# Final Drainage Report Redlines.pdf Markup Summary

**EXISTING CONDITIONS
 FINAL PLAT
 VILLAGES AT LORSON RANCH**

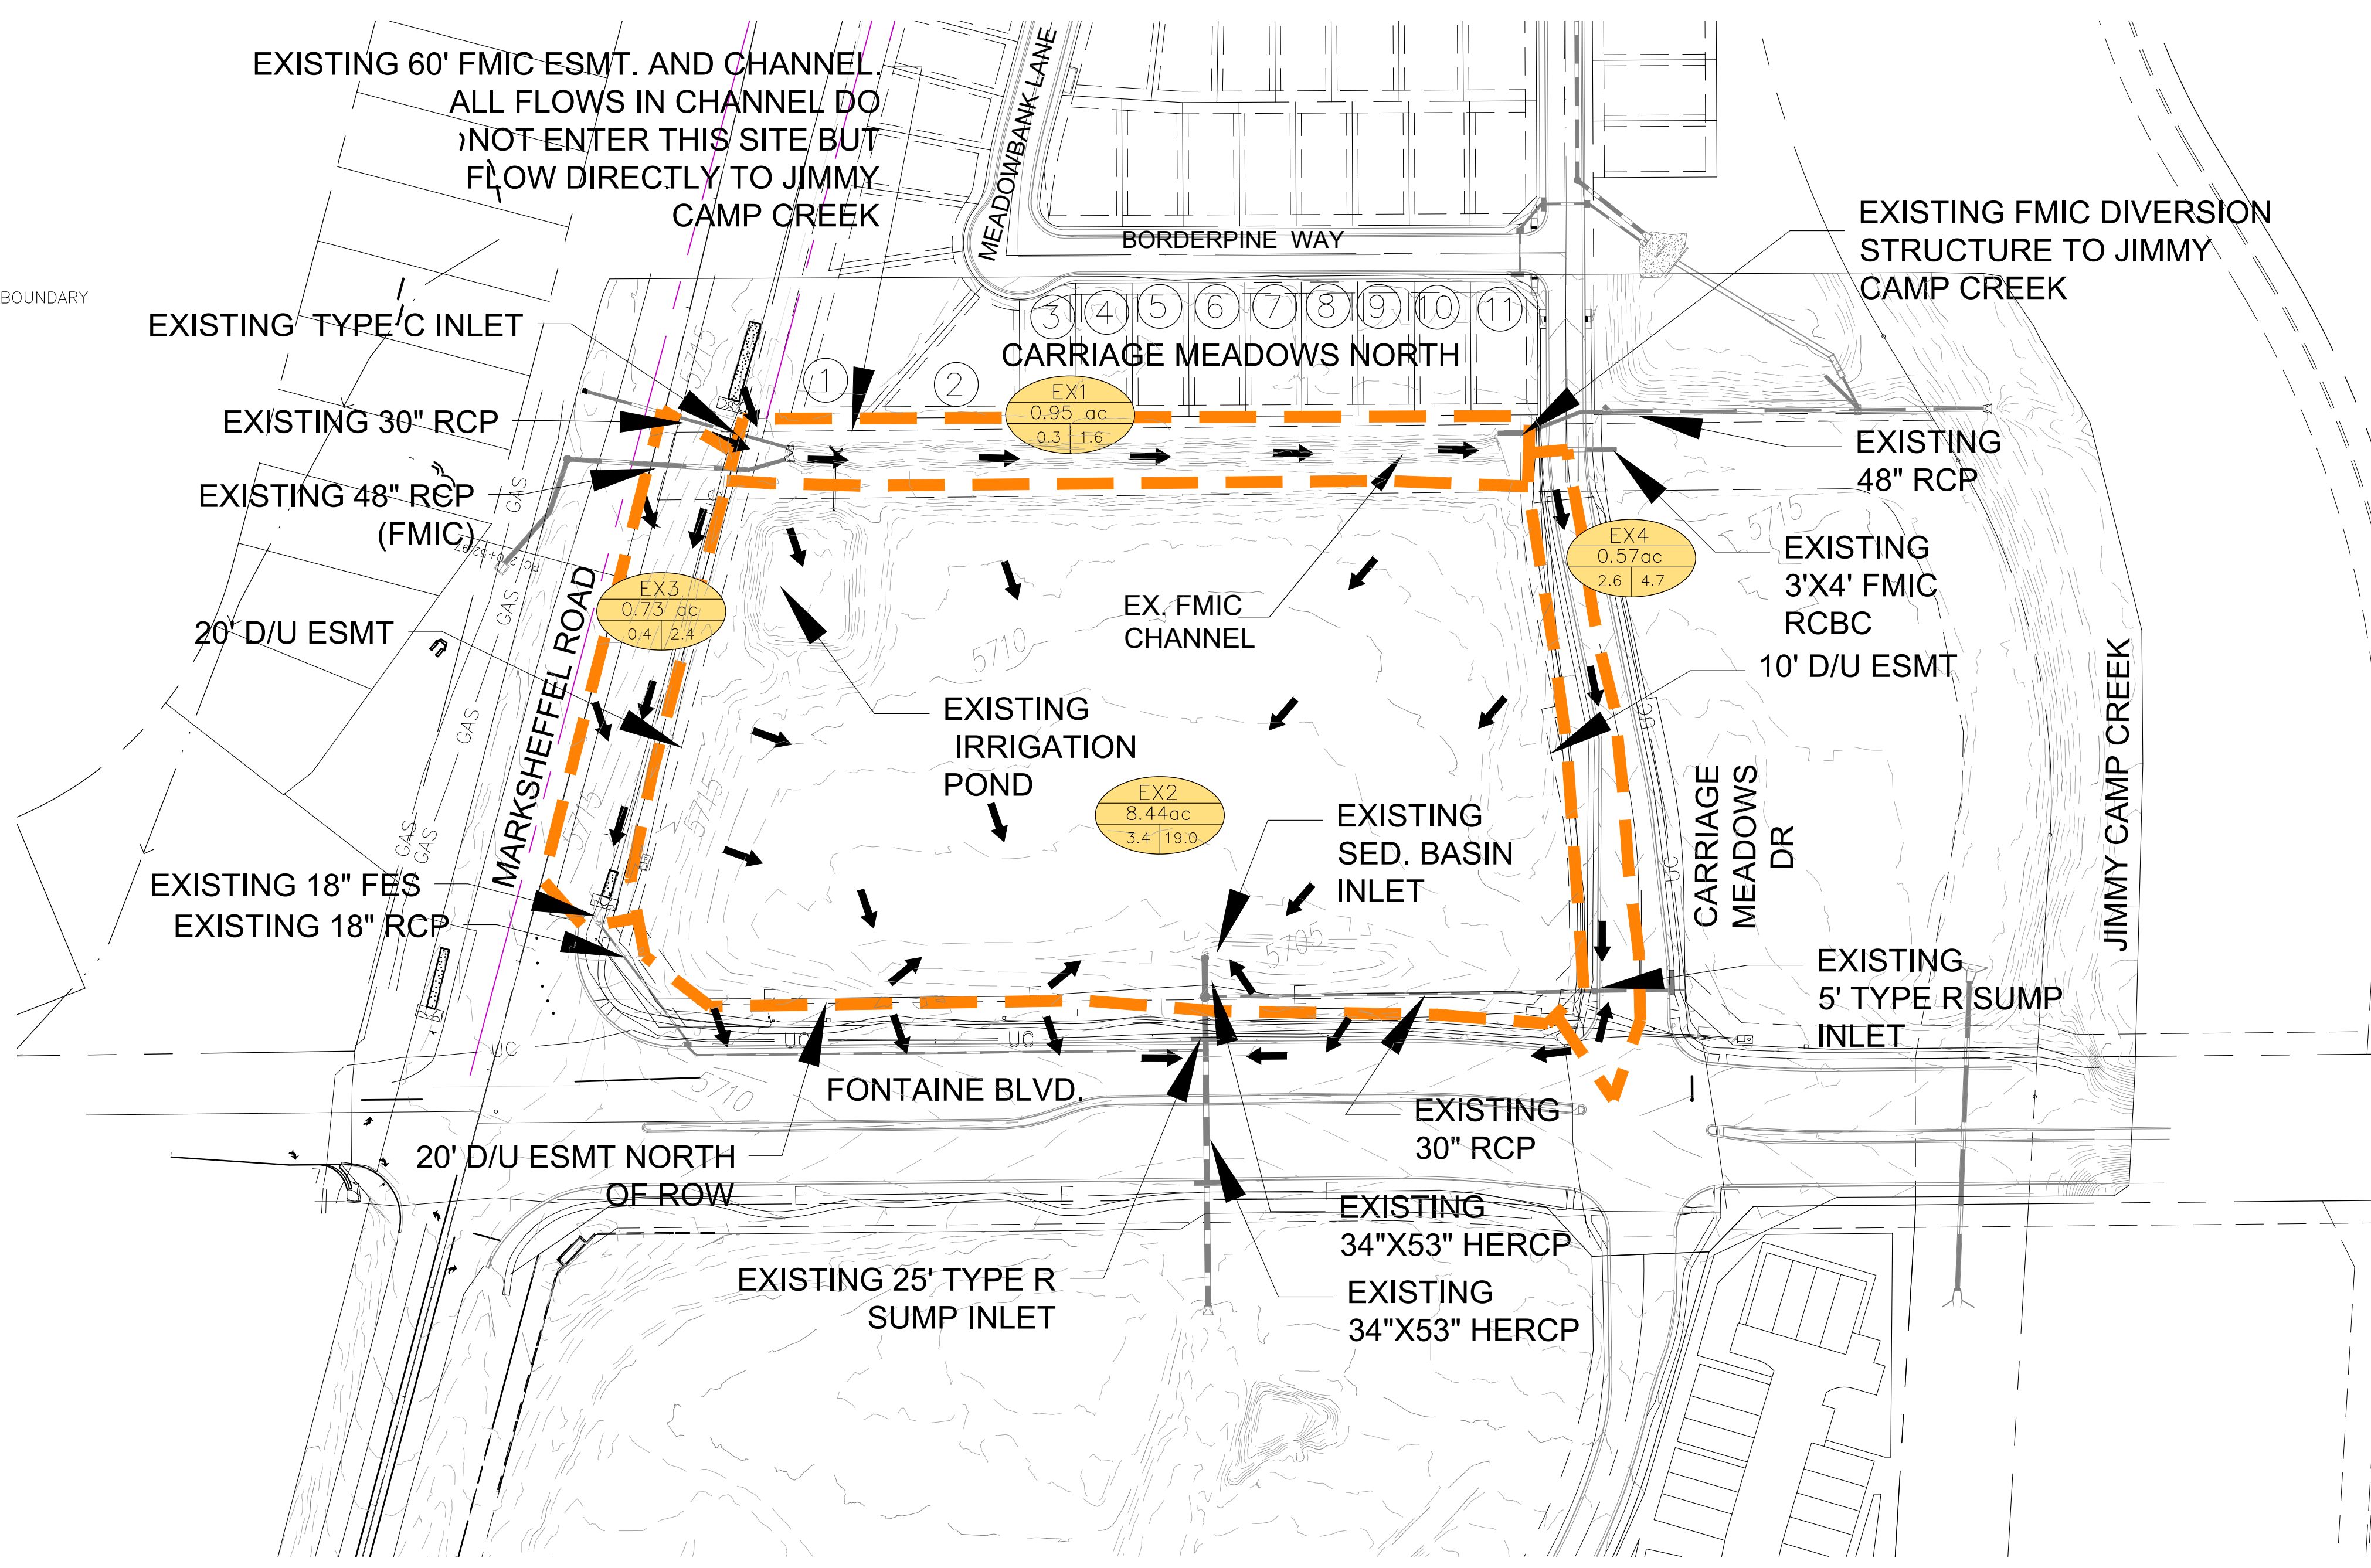
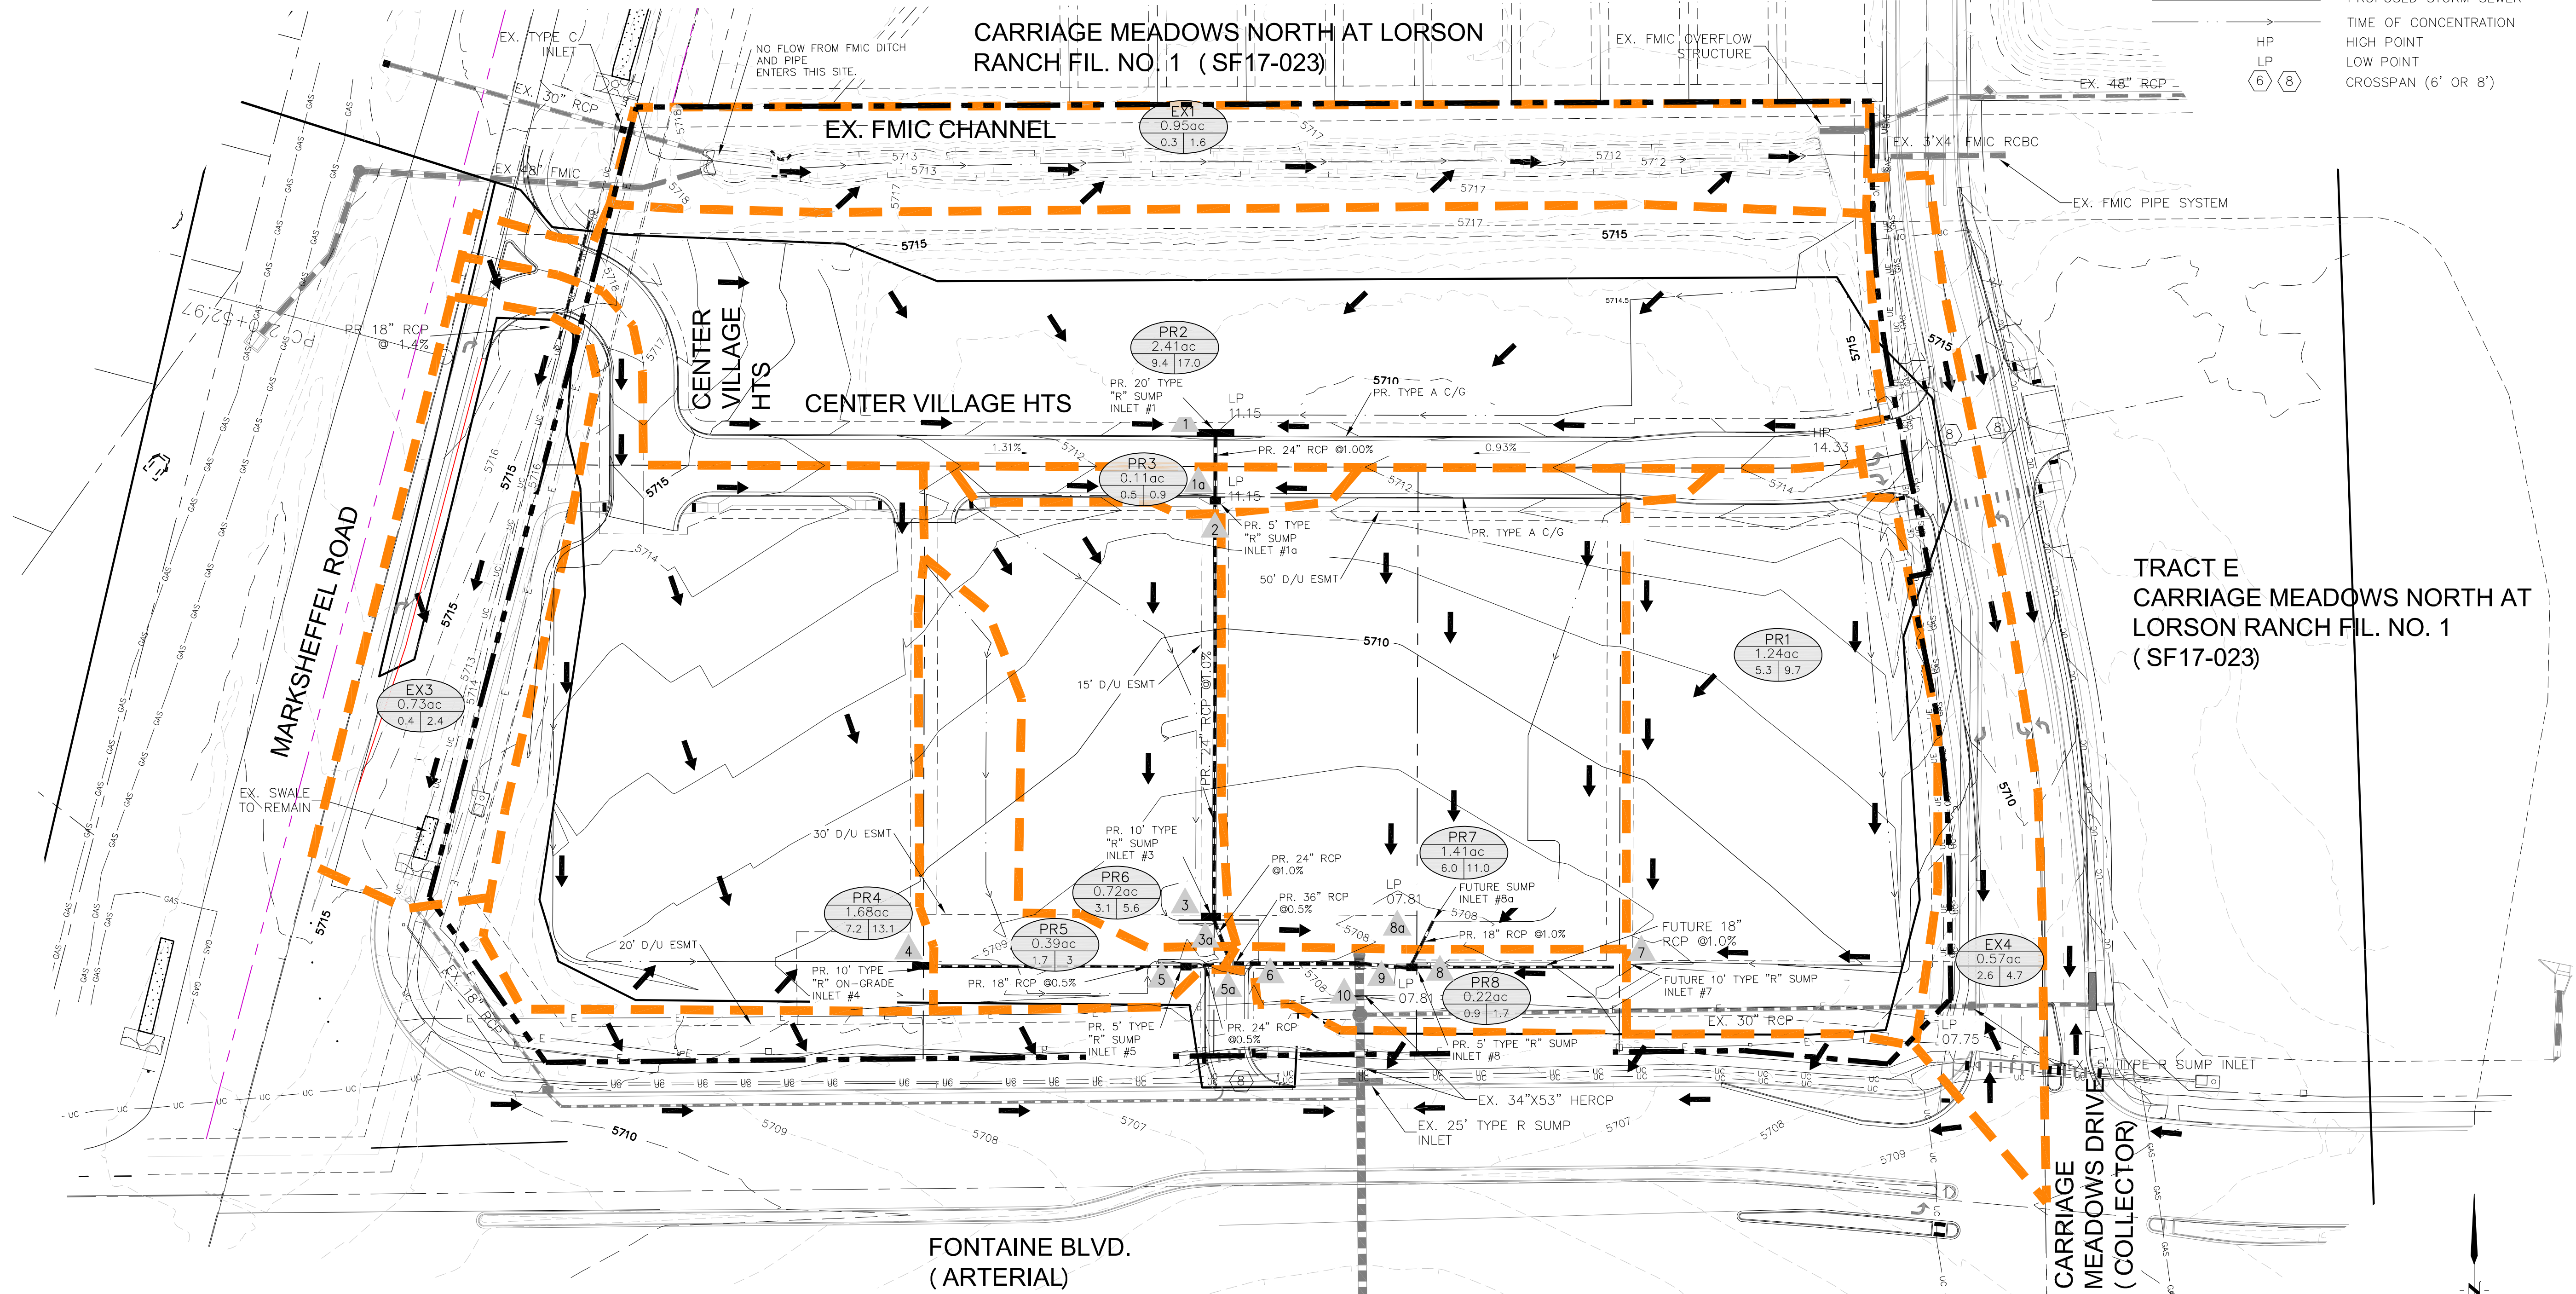
Unresolved: Label all adjacent property owners

Unresolved: Show and label all existing easements

Unresolved: Label all existing storm structures (several labeled on proposed map that are not labeled on this map).

property owners added

easements labeled/shown

structures labeled.
